**MIXED USE DEVELOPMENT (SSD 8440 MOD 2) 42 HONEYSUCKLE DRIVE
NEWCASTLE**

I refer to the Department's letter of 8 April 2019 advising Doma Holdings (Honeysuckle) Pty Ltd has submitted an application to modify the development consent for the above development and inviting City of Newcastle (CN) to comment.

**42 Honeysockle Drive,  
Newcastle**  
General Arrangement Plan  
Ground Floor

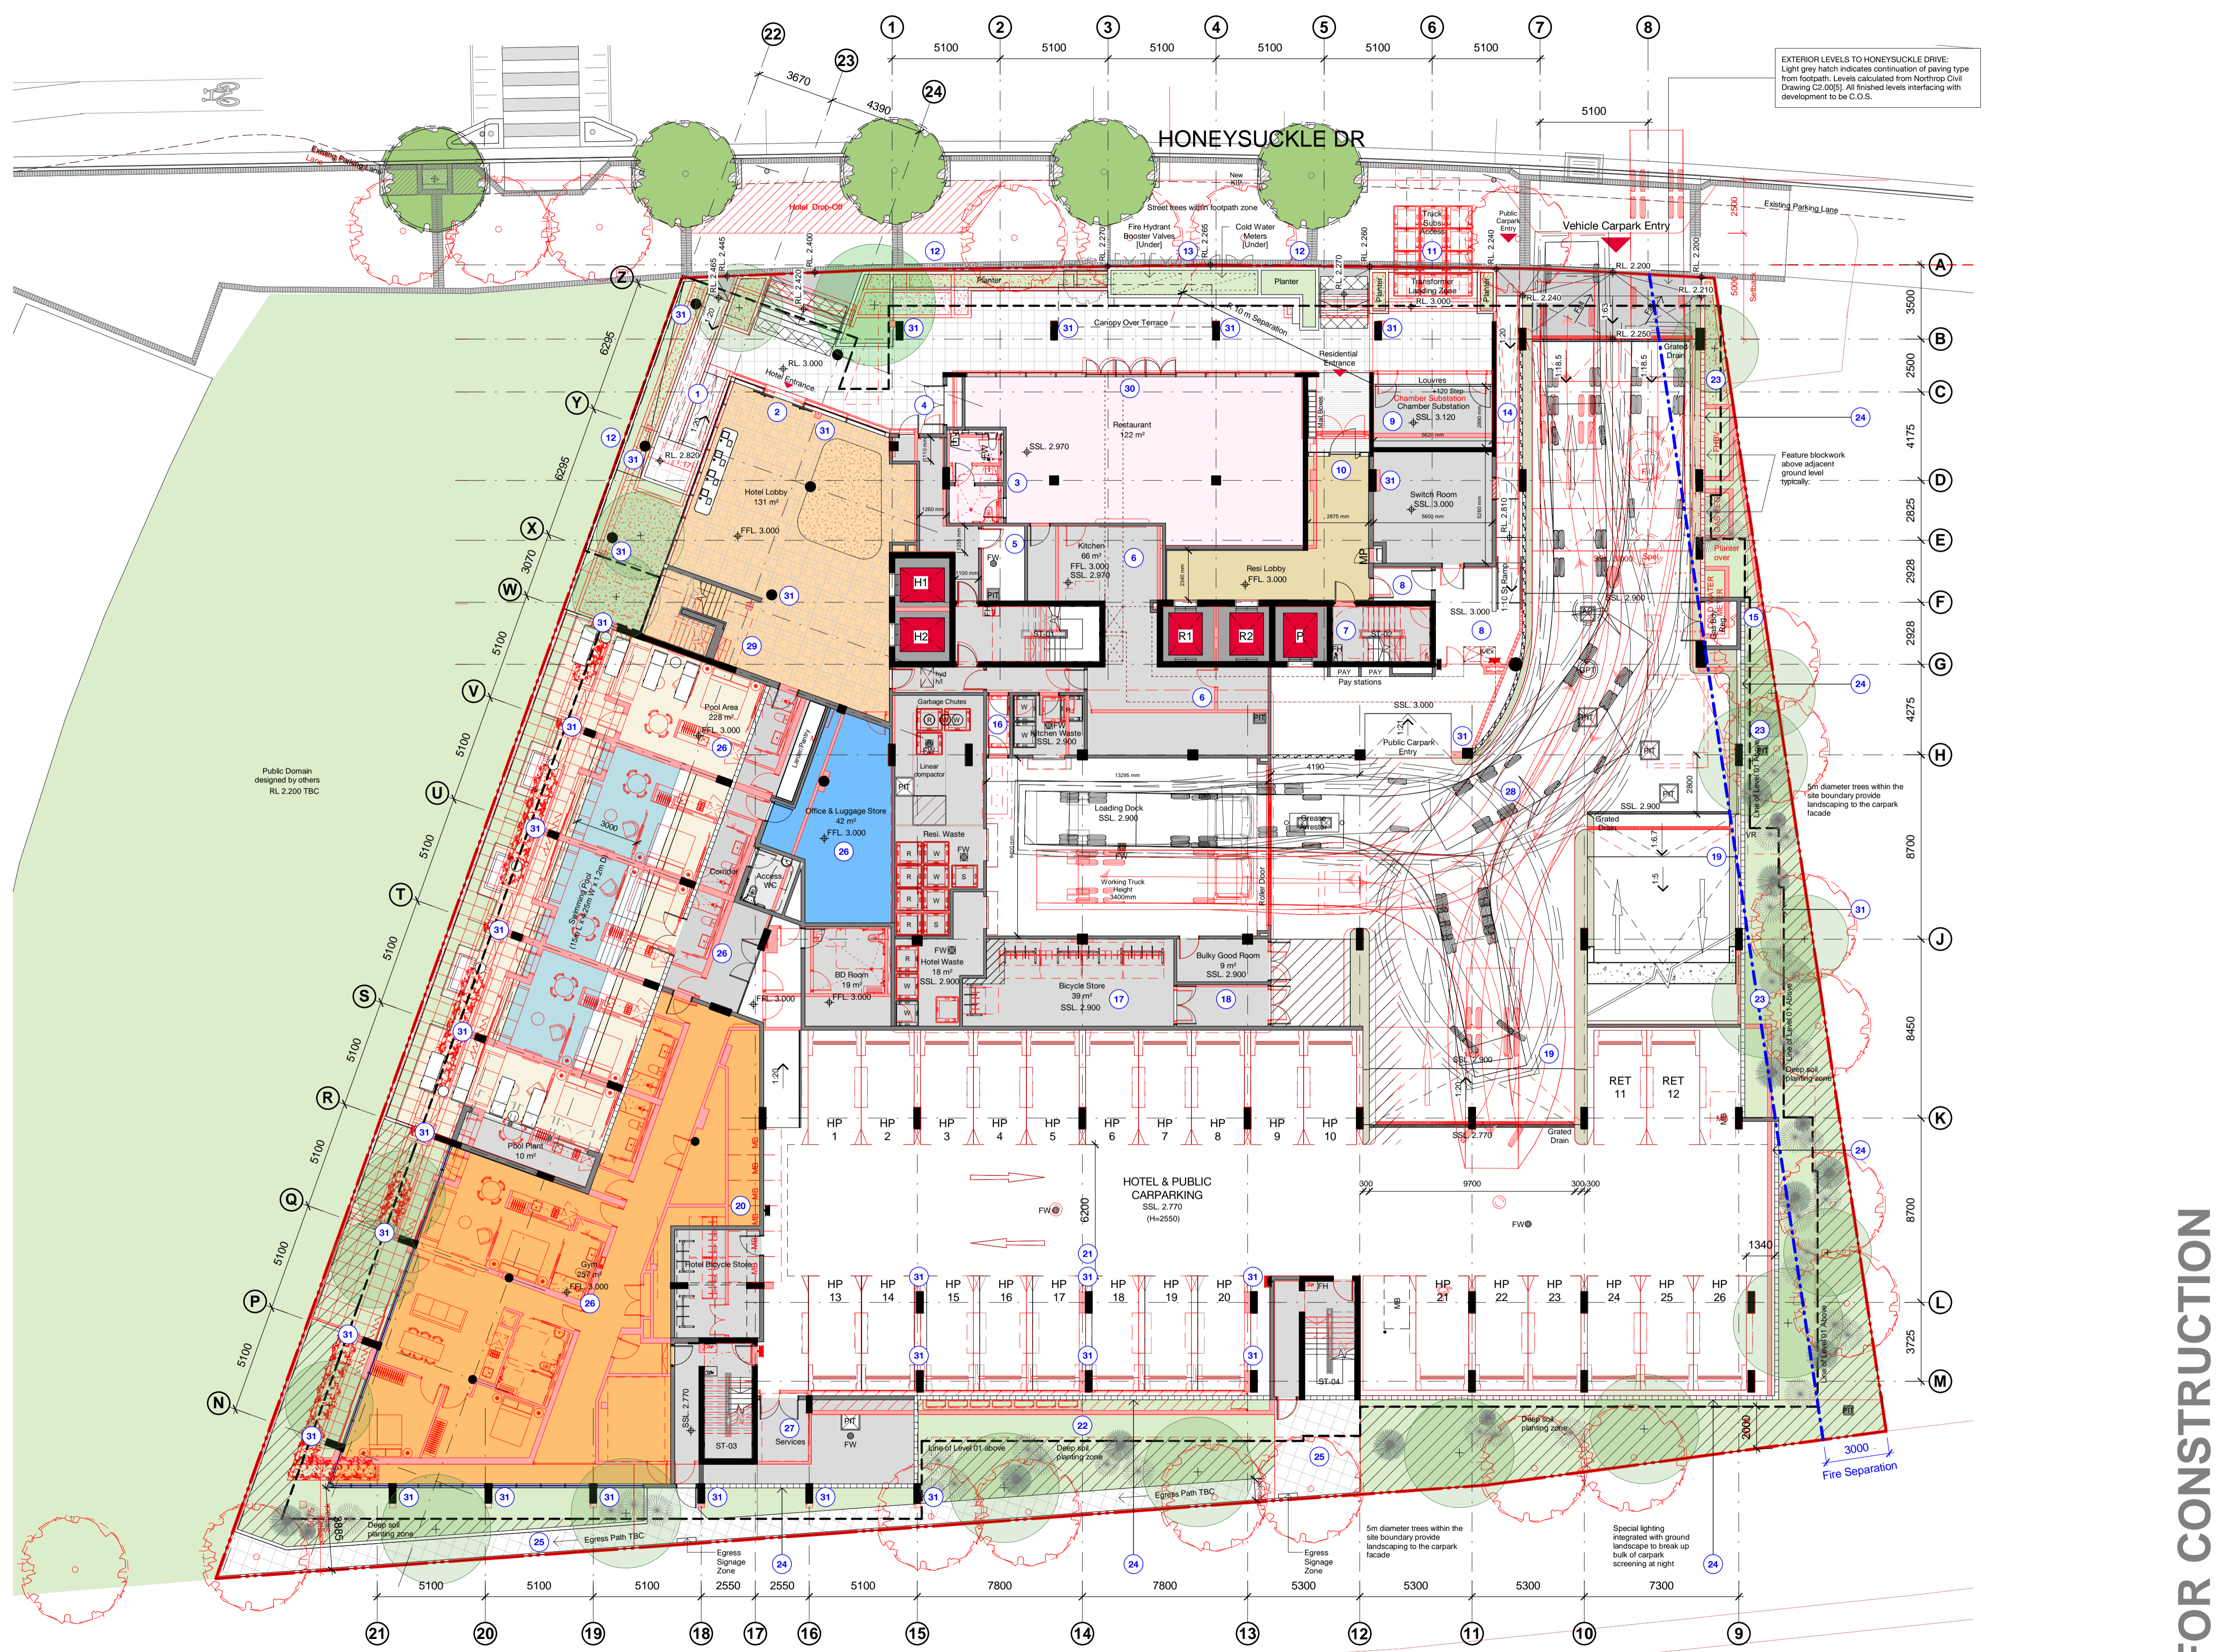
The modified General Arrangement Plan for the ground floor nominates the approved retail premises as a restaurant. Consideration should be given to the likely impacts of this use on the dwellings and hotel rooms above, including the imposition of an appropriate condition regarding hours of operation. It is noted that this use was not addressed in the acoustic report submitted in support of the development application. Further, it is not indicated as to whether the restaurant will include outdoor tables and seating.
